From: Contact Centre (CRM) <contact@ribblevalley.gov.uk>
Sent: 06 June 2023 21:24
To: Planning
Subject: Planning Application Comments - 3/2023/0352 FS-Case-521976041

Planning Application Reference No.: 3/2023/0352

Address of Development: 10 Manor Road, Whalley BB7 9TE

A3.3

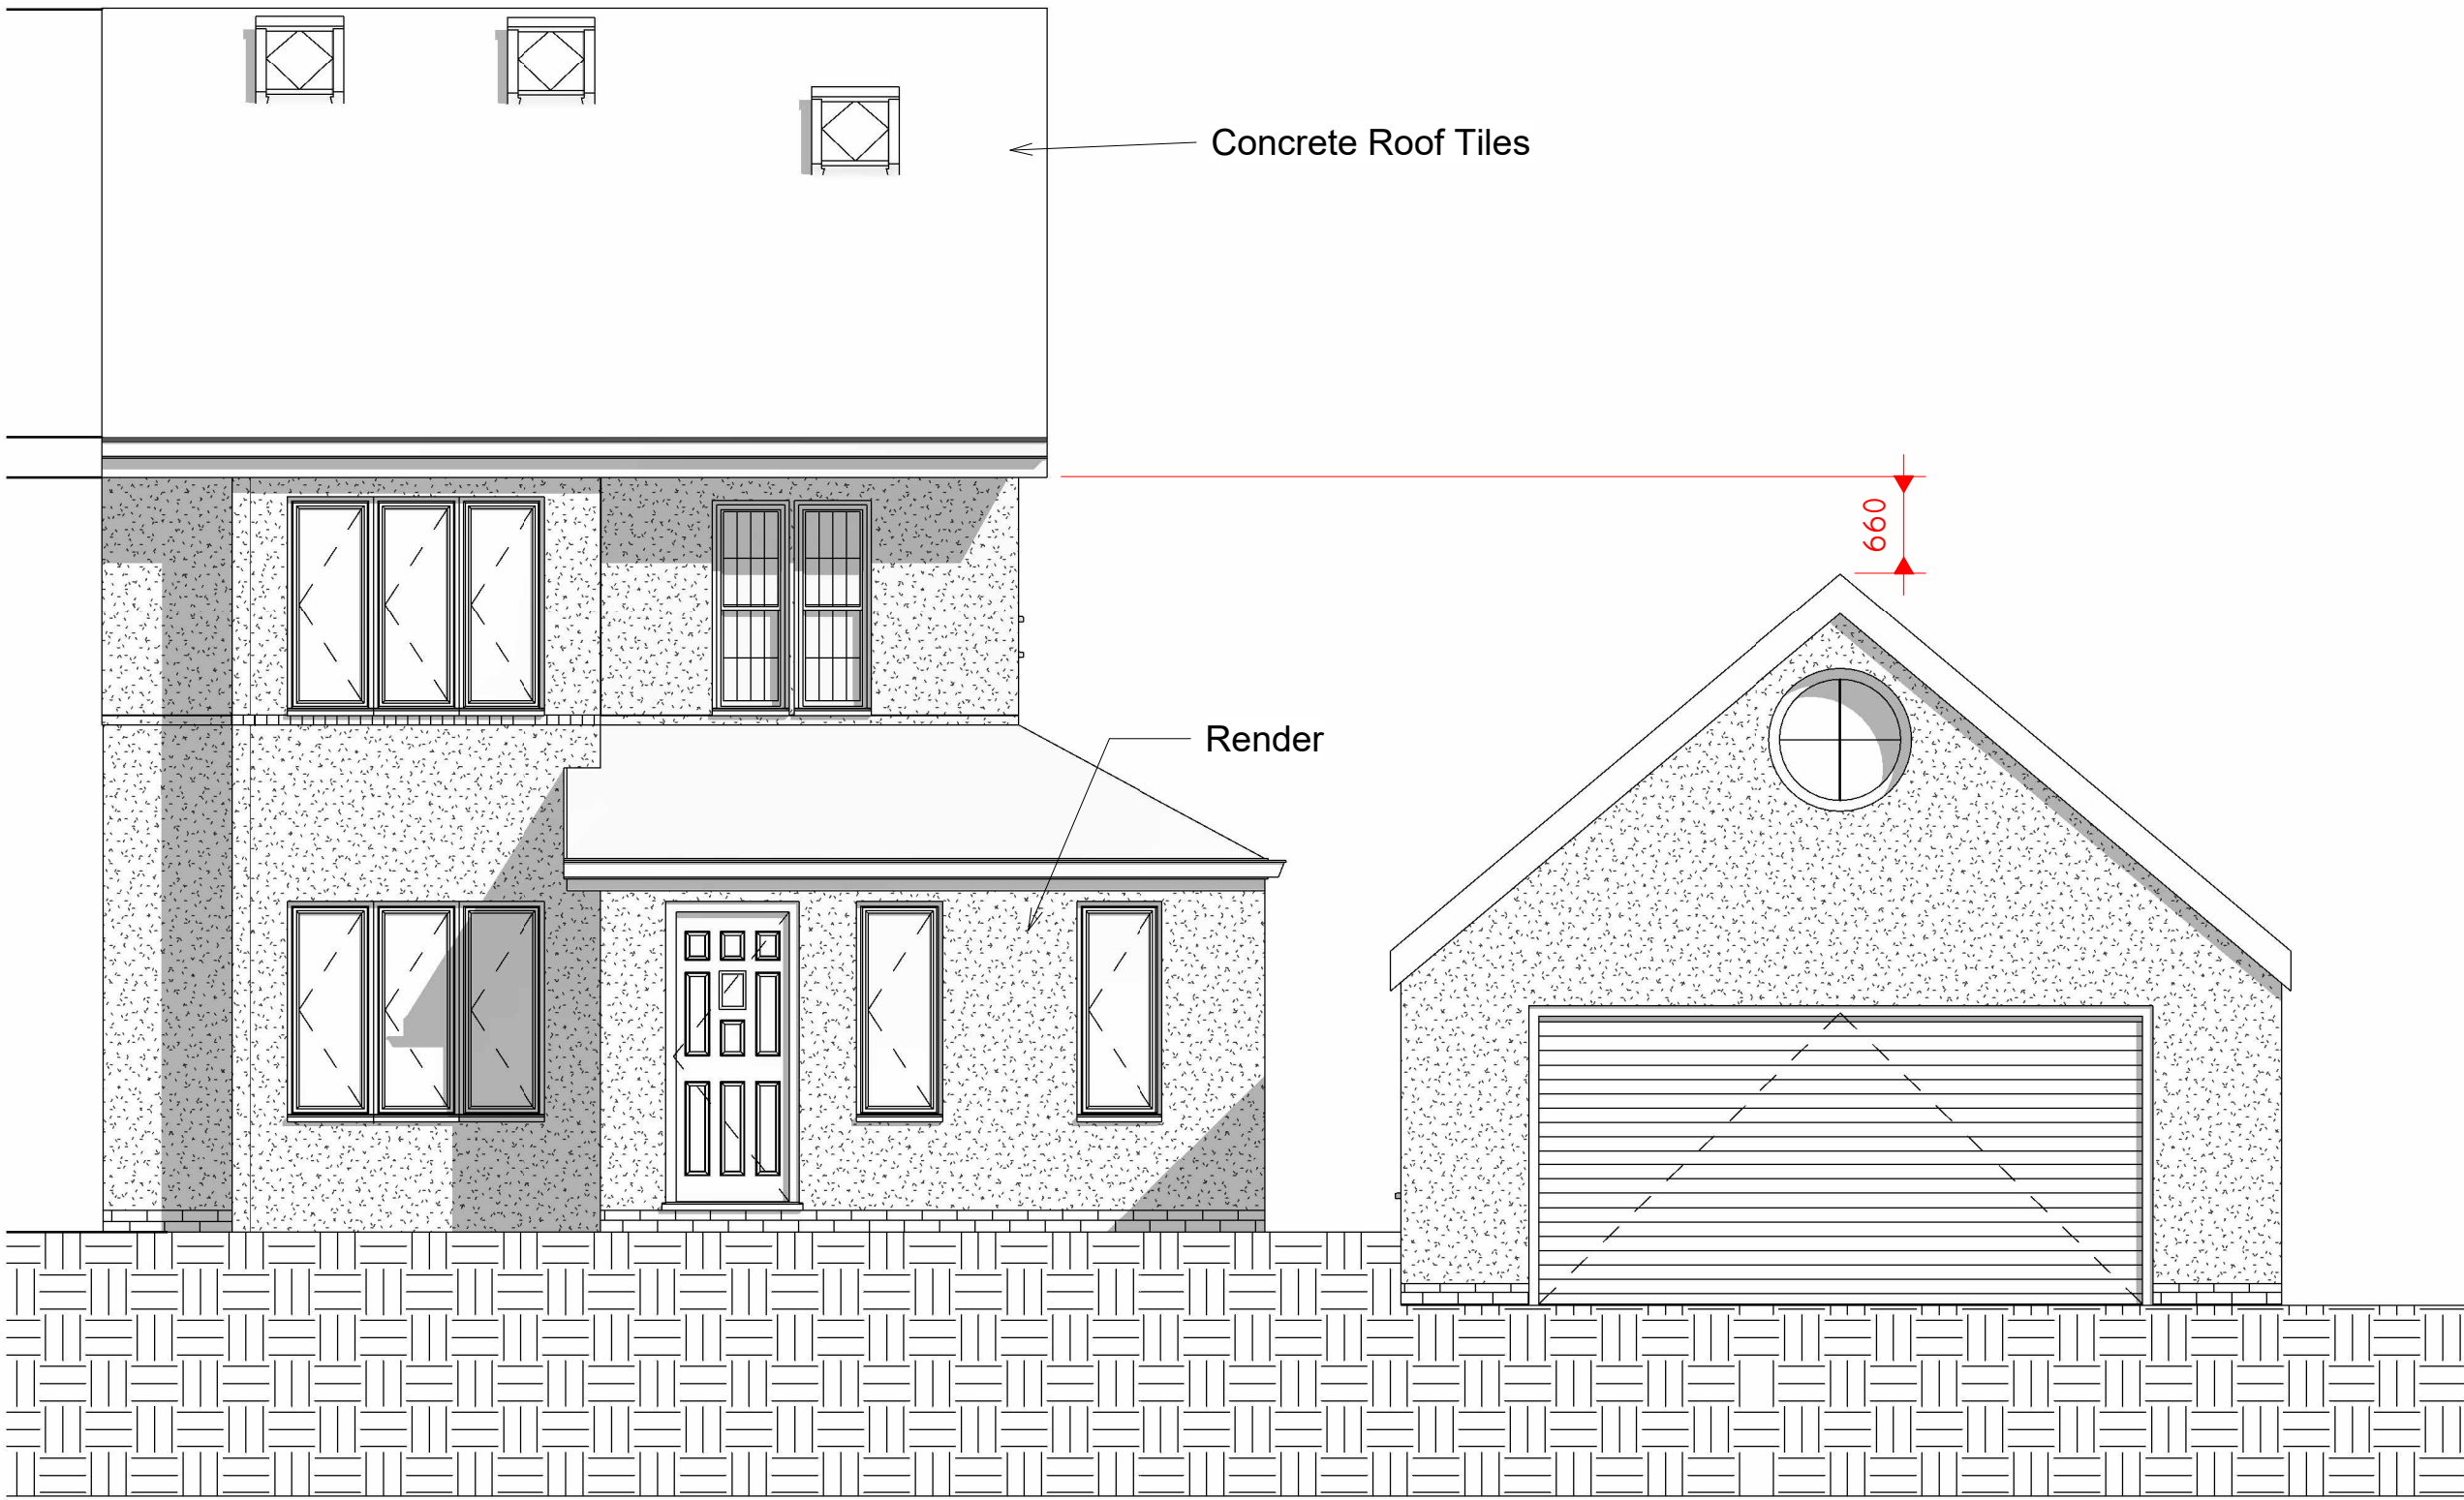
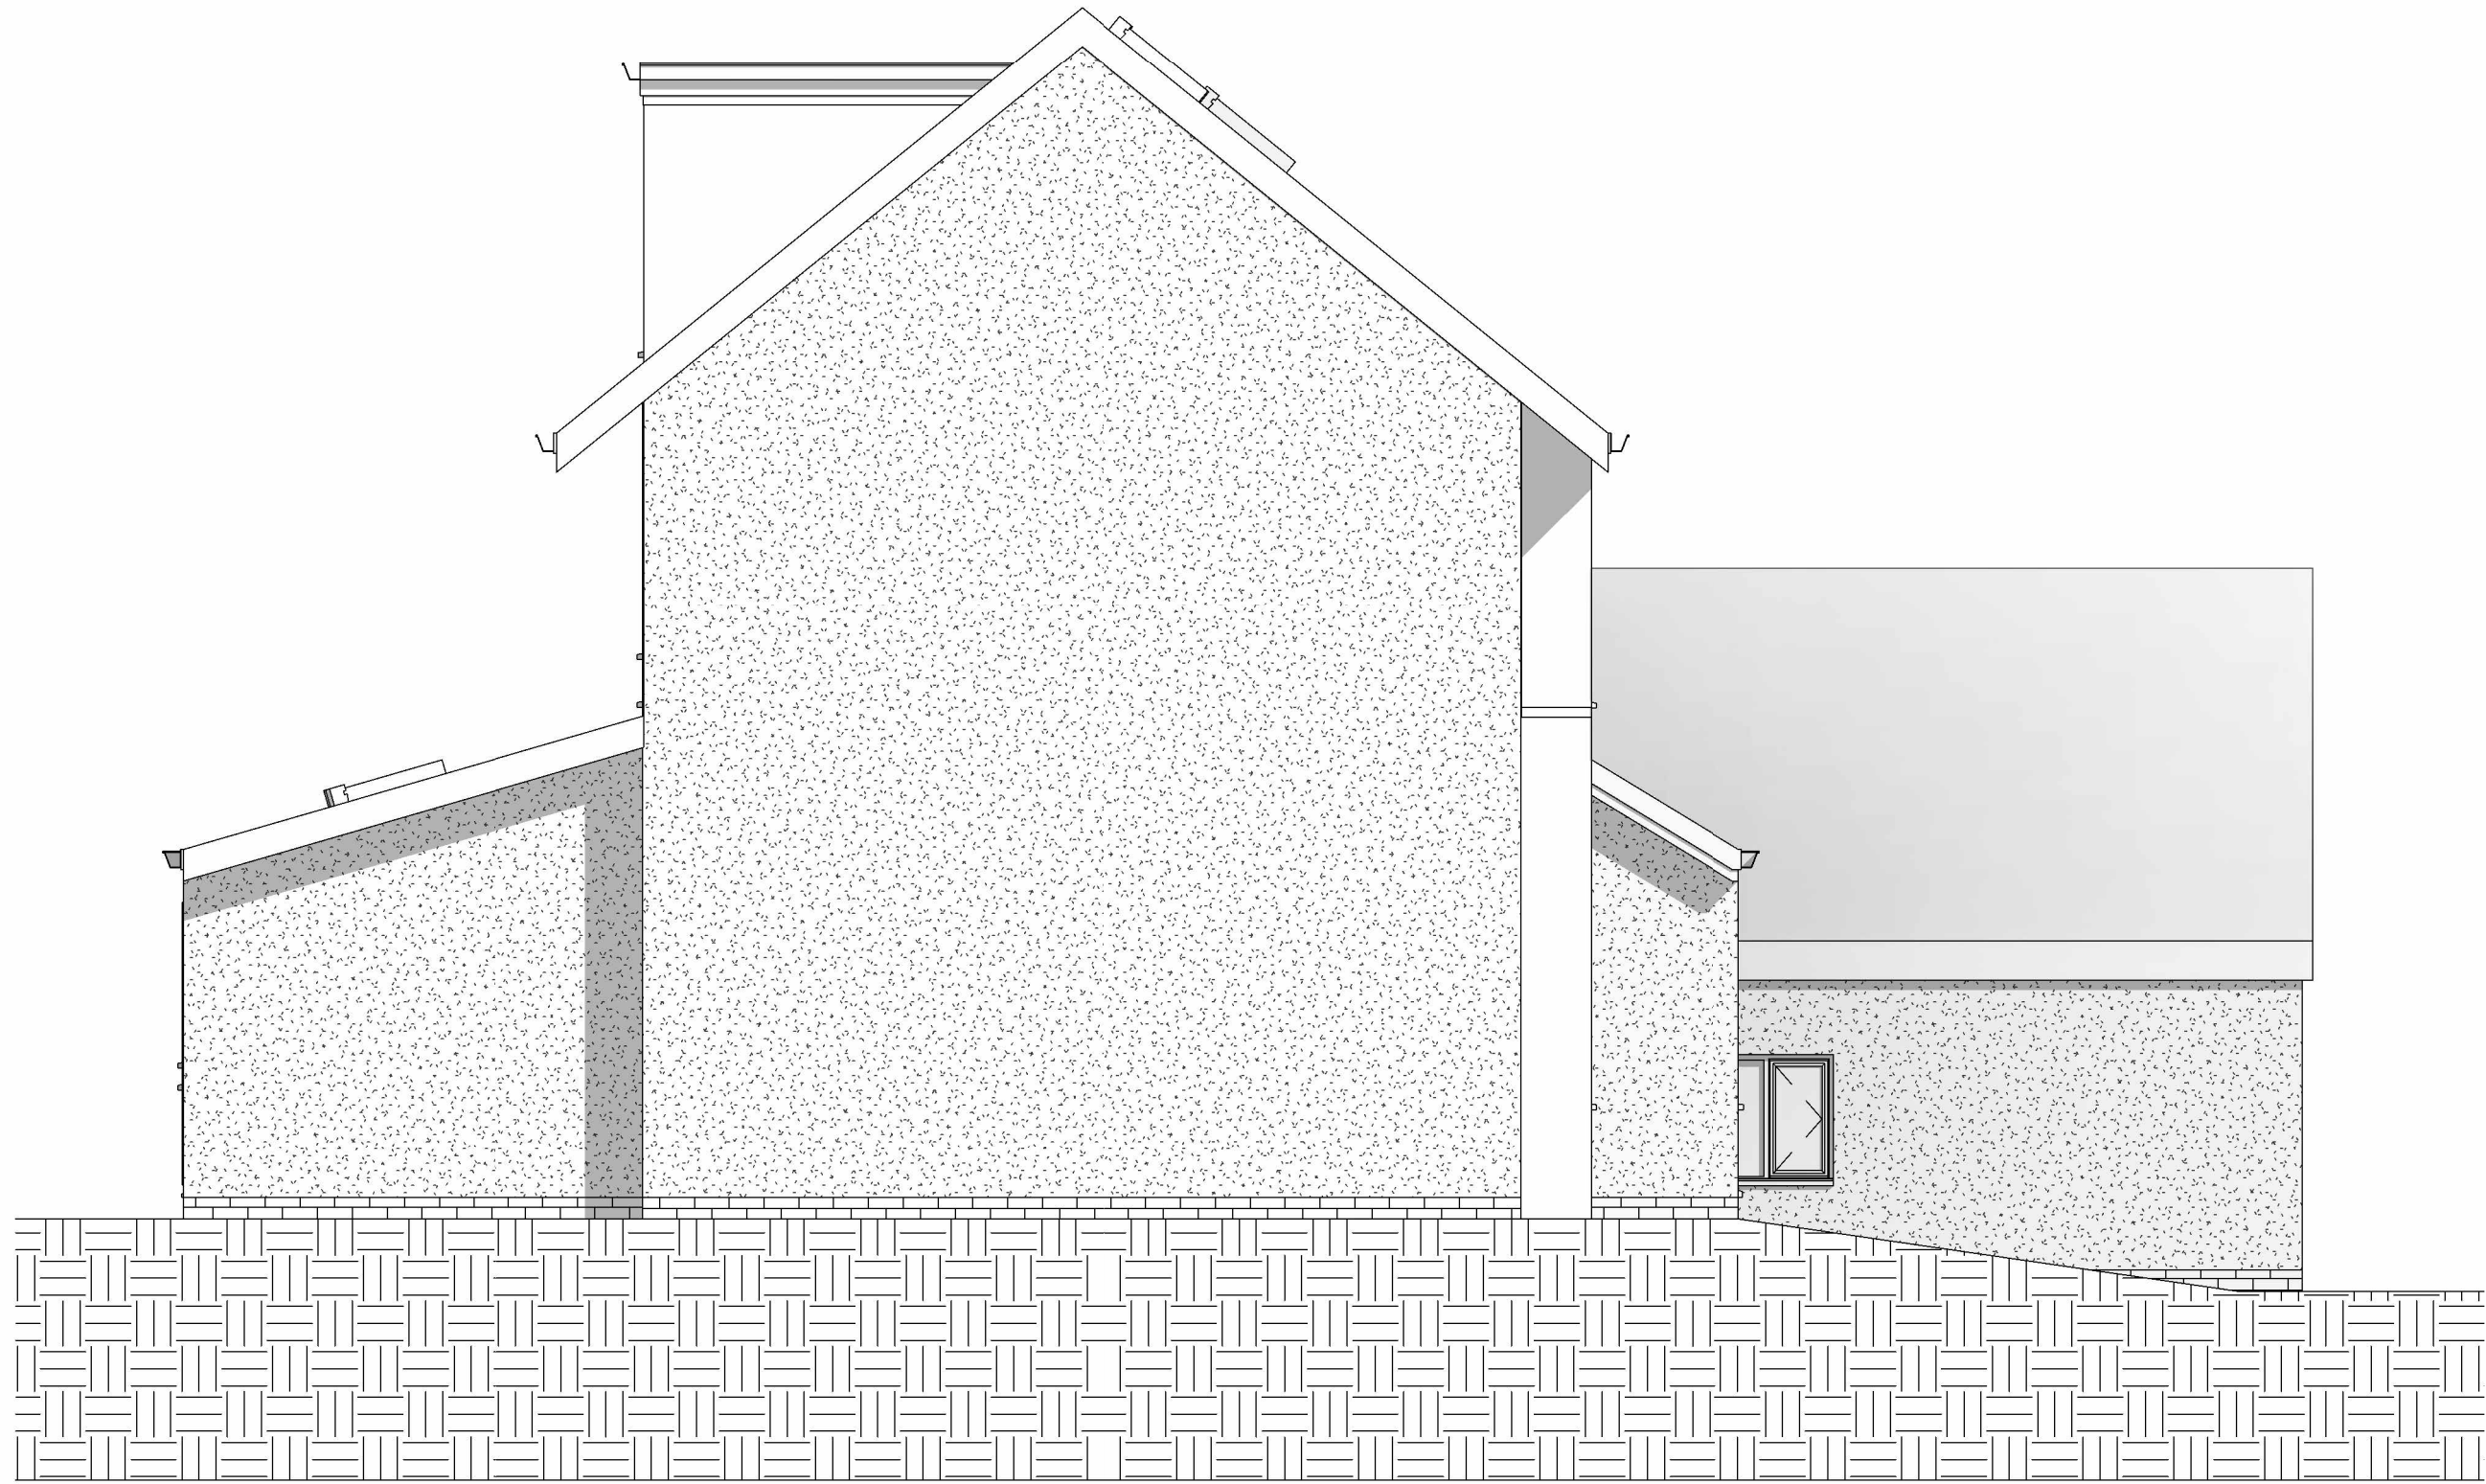
- 1) Confirm the rear extension (that is [REDACTED] will be constructed wholly on the land of no 10 Manor Road - [REDACTED] Out of interest not received any correspondence in relation to the [REDACTED]...which I'd have thought would be necessary ?Would also be interested to know if the owner/contractor believes they'll be accessing [REDACTED] actually construct this rear extension ?
- 2) Because the proposed rear extension is to extend 1m beyond its correct line/footprint, which means the existing lean-to roof will be at a different angle, what is the intended arrangement/detail between the new lean-to roof and next door (where the steeper pitch remains the same);
- 3) Not sure if square bay windows are to be constructed or angled bays - as the proposed plans show square and the elevations show angled (while not particularly bothered either way - would be good to know).
